# One Earth Solar Farm

**Draft Statement of Common Ground with Historic England**

**EN010159/APP/8.7.2**

November 2025

Viewpoint 26b      View from Fledborough Viaduct, west of the River Trent (Winter)

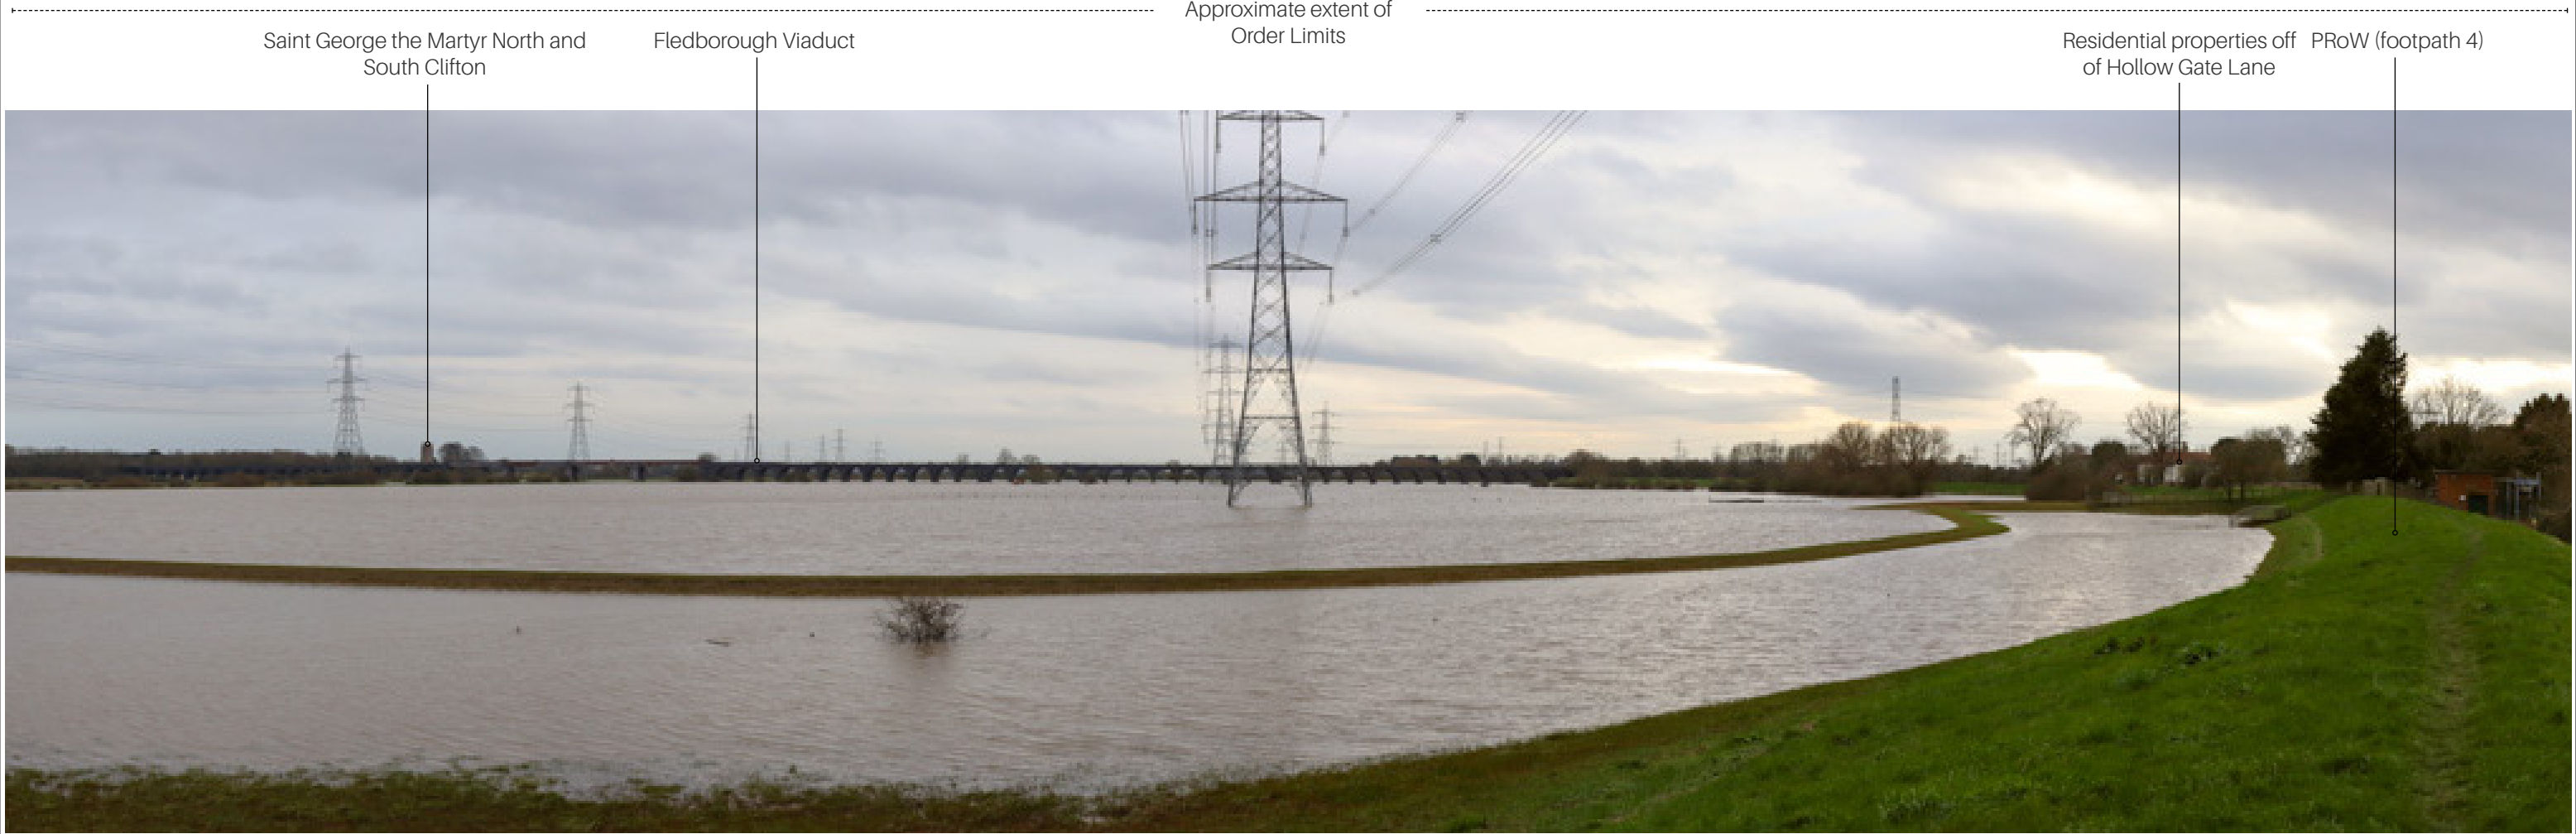
confirmed in subsequent response to Relevant Representation, there would be no impact to the Church.	
02-06	Impact on built heritage assets	<p>Further understanding required on field to the north of North and South Clifton as viewed from Fledborough Viaduct.</p> <p>Further detail can be found in Historic England's Relevant Representation [RR-019, 190], as well as email correspondence in December 2024 – January 2025.</p>	The understanding of Proposed Development in relation to North and South Clifton is supported by LVIA photomontages (Views 25a, Figure 11.13.7a, [AS-038]) and Zone of Theoretical Visibility (Figure 10.3 [APP-055]). The effect on heritage assets within North and South Clifton is provided in pages 51-53 and page 57 of ES Chapter 10 [APP-039]. There are no harmful effects identified to these assets.	<b>Under Discussion</b>
02-07	Mitigation	<p>Historic England have requested for mitigation to be provided at western substation (Gibraltar Farm) and consideration of associated impacts, i.e. lighting.</p> <p>Further detail can be found in Historic England's Relevant Representation [RR-019, 190], as well as email correspondence</p>	The mitigation for Gibraltar Farm has been clarified at 10.5.5 of ES Chapter 10 [APP-039], and the assessment has been provided at 10.6.65 - 67. The mitigation provided is considered to be proportionate to the very low value of this asset. And this location is considered preferable to others, as per the response to comment 02-02 above.	<b>Under Discussion</b>
